STATE OF NORTH CAROLINA
DEPARTMENT OF TRANSPORTATION

December 16, 2011

Subject: **Permit Modification Request for the Individual Section 404 Permit, Individual Water Quality Certification, and CAMA Permit** for the widening of US 158/NC 34 from East of Pasquotank River to the US 158/ NC 34 split in Camden County. Federal Aid Project No. STP-158(2), Division 1, TIP Nos. R-2414 A&B. Debit \$670 from WBS 34430.1.1.

Please see the enclosed revised permit drawings (Sheets 1, 14, 15, 16, 17, 29, 30, 31, 32 of 38), roadway drawings, and revised EEP Acceptance Letter for the above referenced project. Due to the continual rejections of bids by contractors due to the stabilization methods, the NCDOT has redesigned the soil stabilization method which has resulted in impact changes at the three culvert locations on the above referenced project. Due to these changes, a permit modification is requested by the Department.

SITE 3

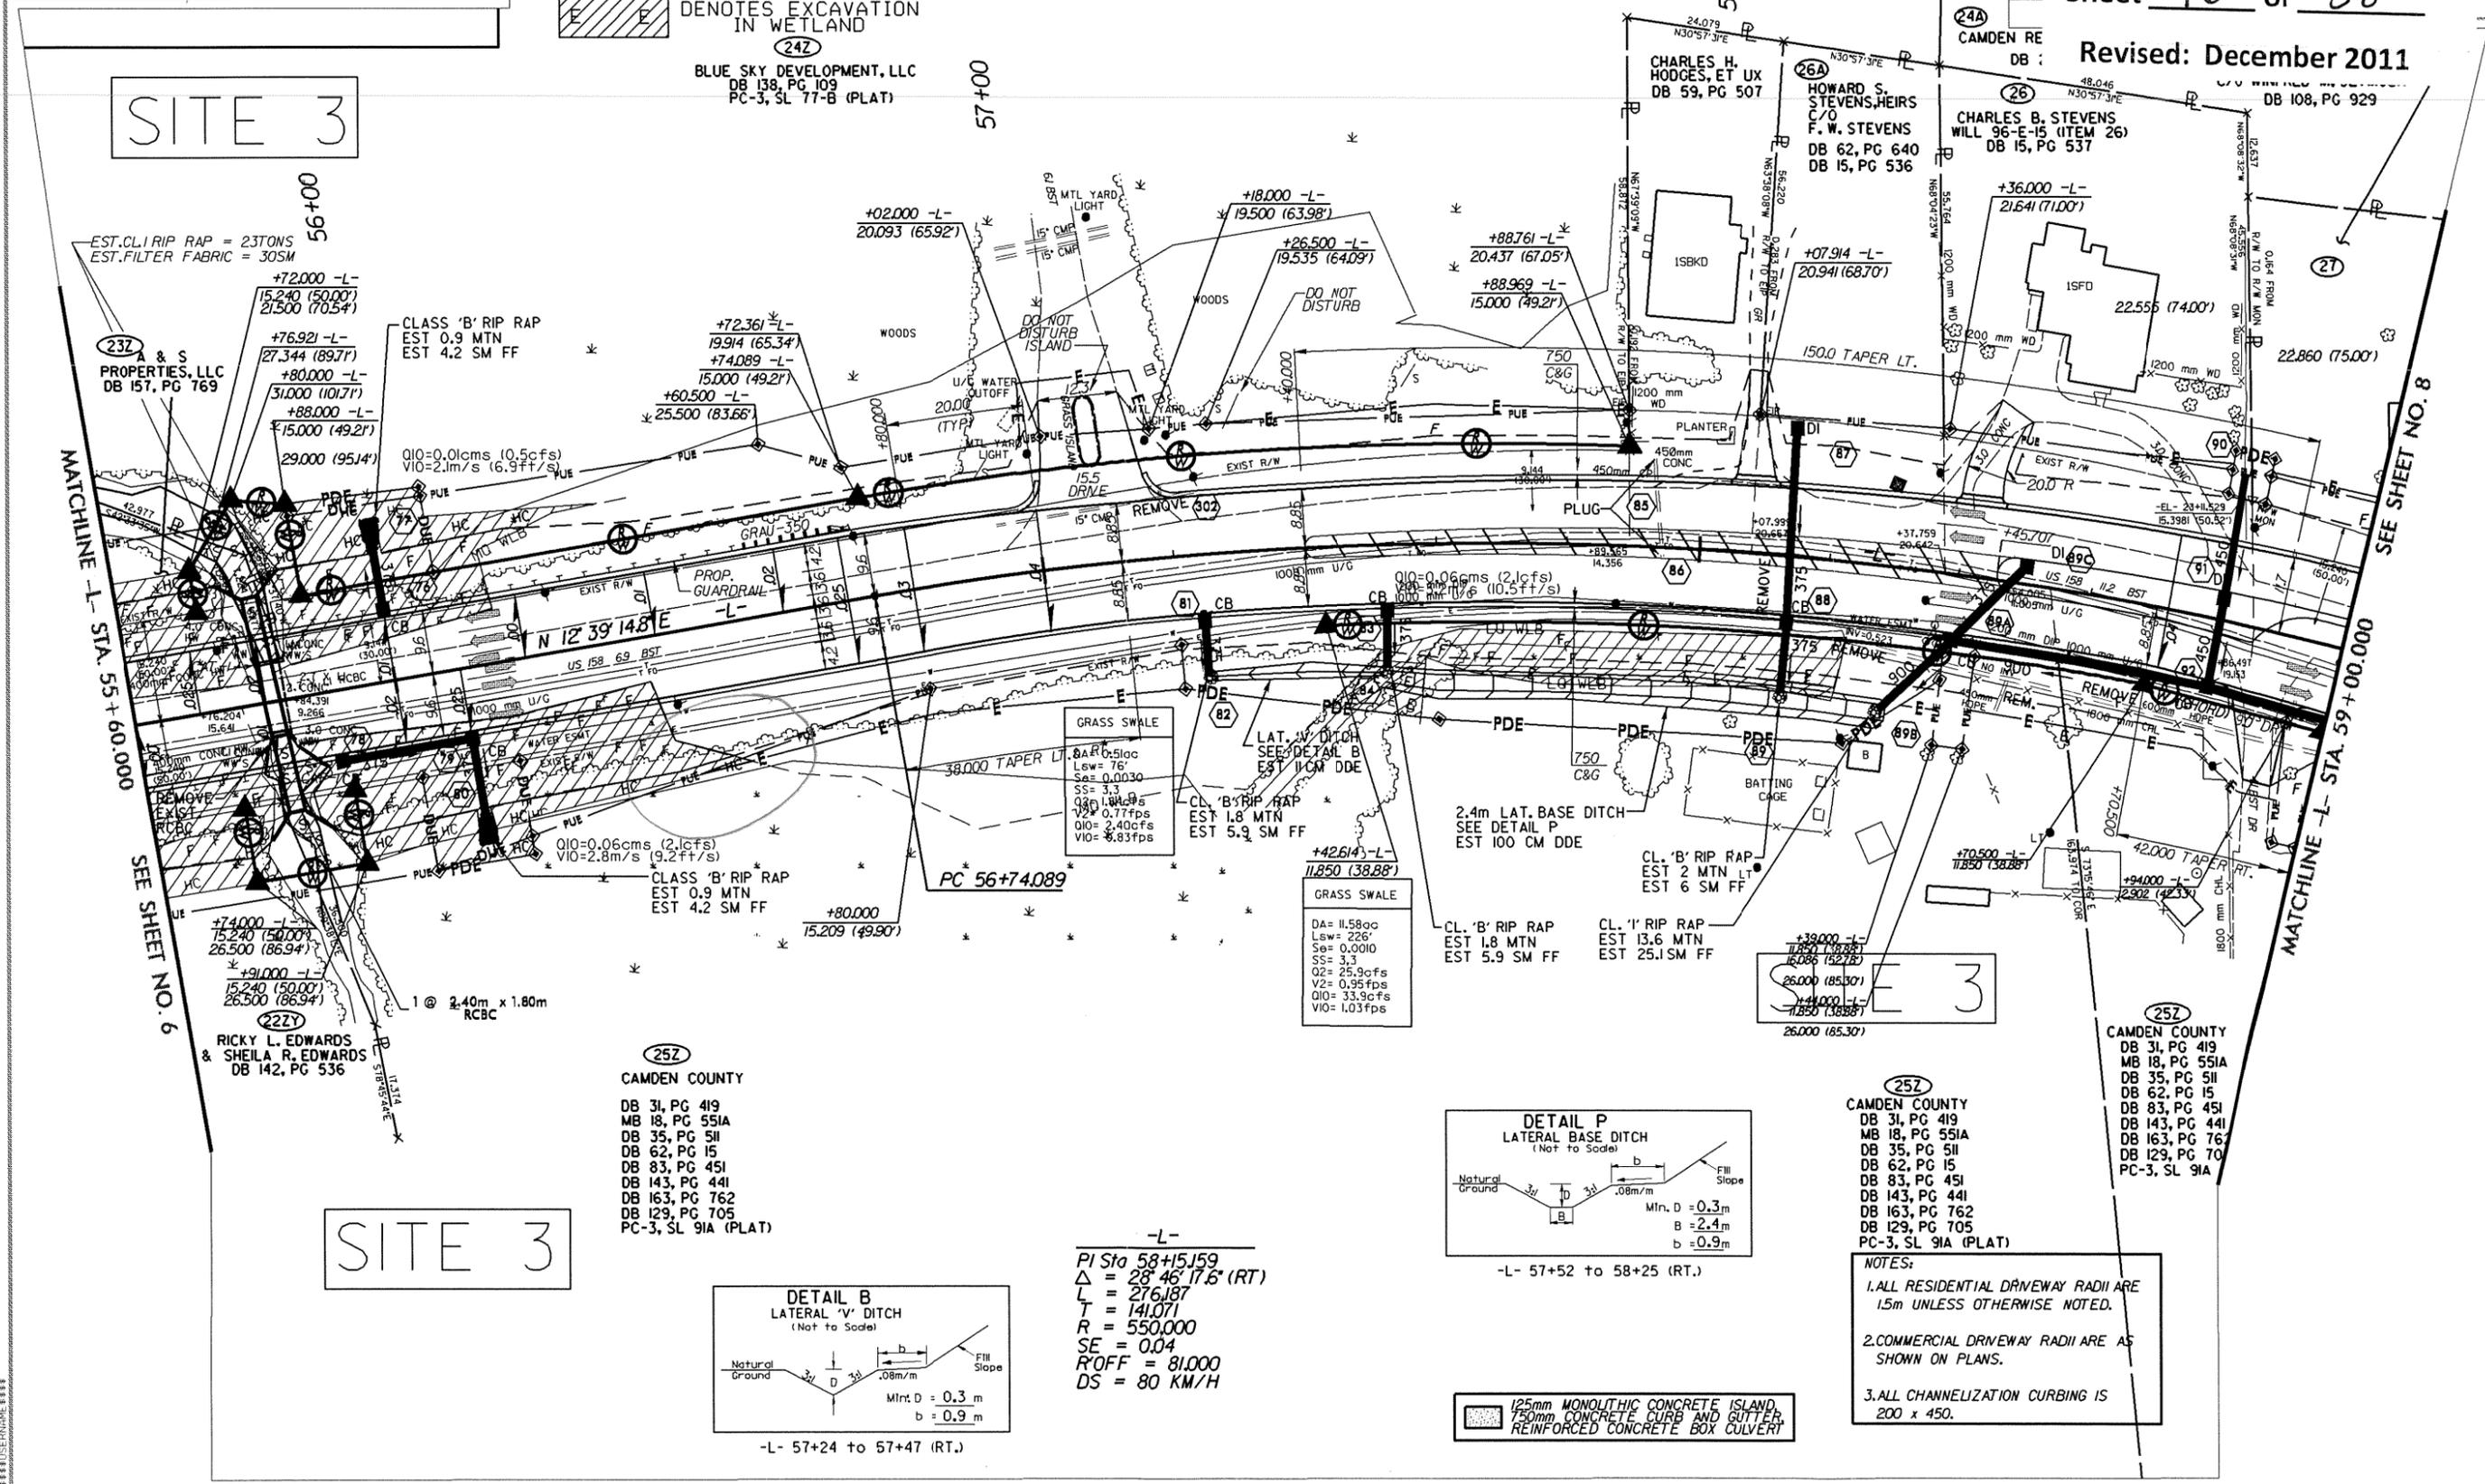
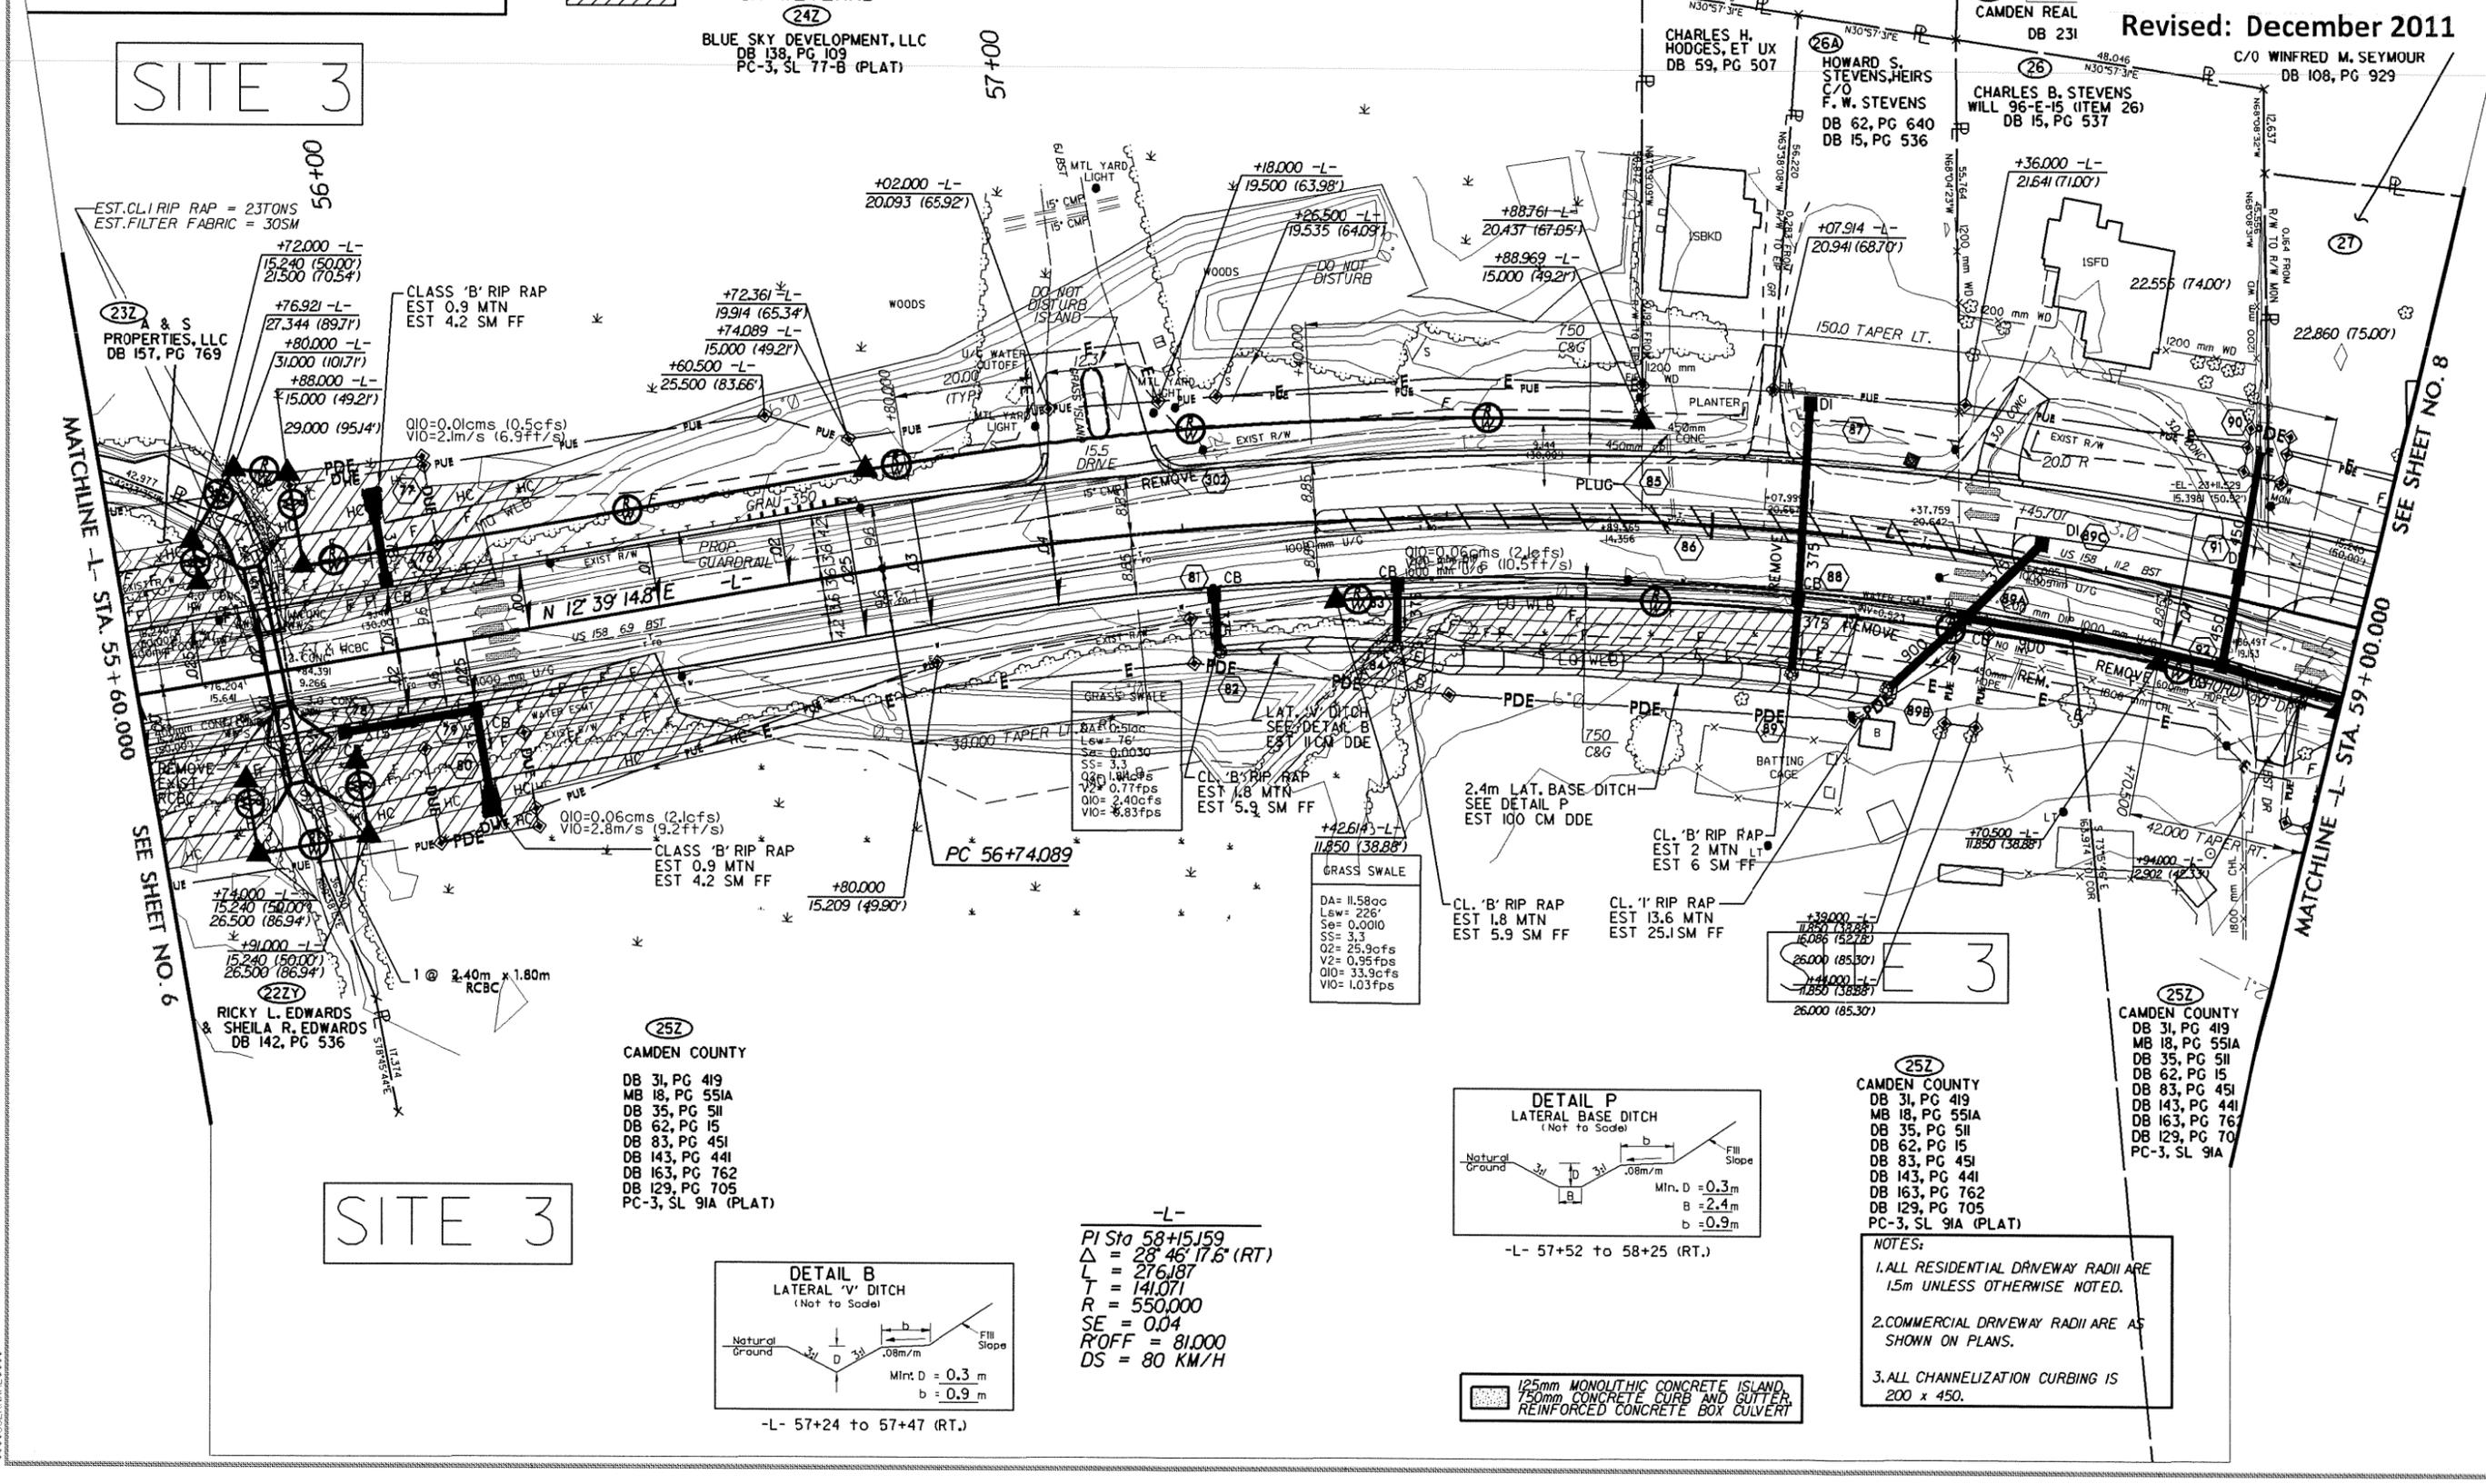
Site 3

The fill slopes will be expanded into a wetland area previously permitted as hand clearing. However, the hand clearing limit will not be expanded at this location. As a result, the permanent fill in wetlands will increase from 0.65 to 0.67 acre, and the hand clearing impact will be reduced from 0.26 to 0.24 acre.

The culvert type has also been reverted back to a single barrel 8’ by 6’ reinforced concrete box culvert (RCBC), as this stabilization method obviates the need for the lightweight aluminum.

Permit Drawing
 Sheet 29 of 38
 Revised: December 2011

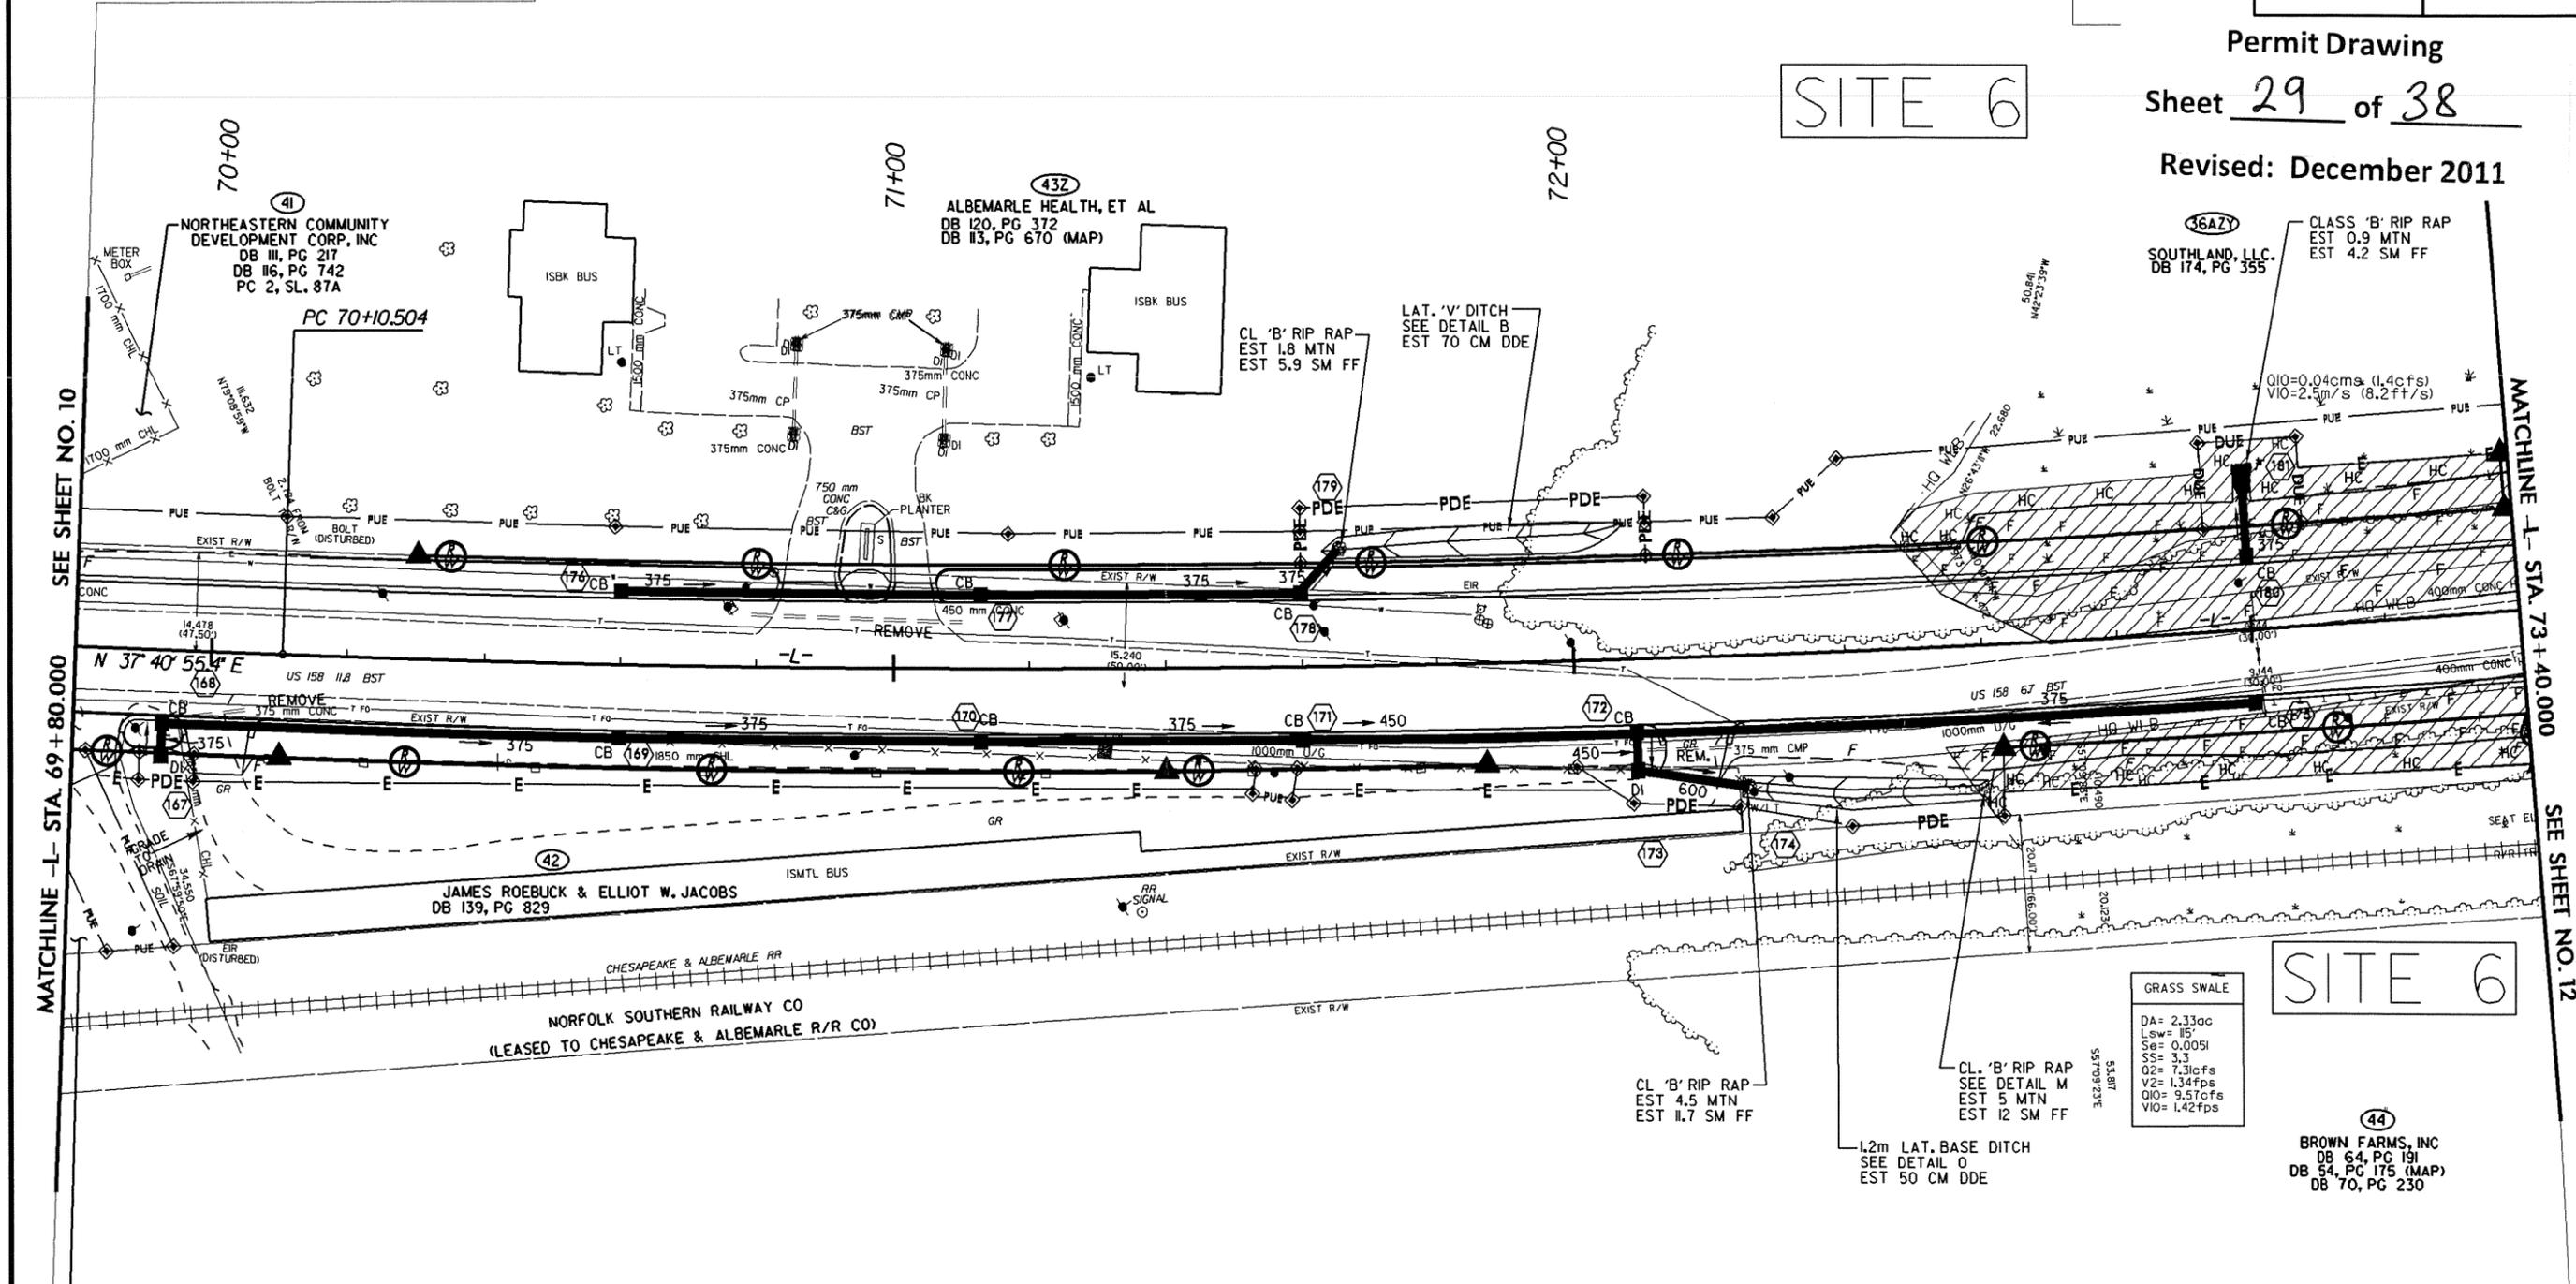
Site 6

The fill slopes will be expanded into an area previously permitted as hand clearing, and the area of hand clearing will also expand out in the amount previously identified in earlier permits (0.37 acre). As a result, the permanent fill in wetlands will increase from 0.85 to 0.87 acre. The hand clearing amount will remain the same (0.37 acre), as it will be moved out from the expanded fill line.

The culvert type has also been reverted back to a double barrel 6’ by 5’ RCBC, as this stabilization method obviates the need for the lightweight aluminum.
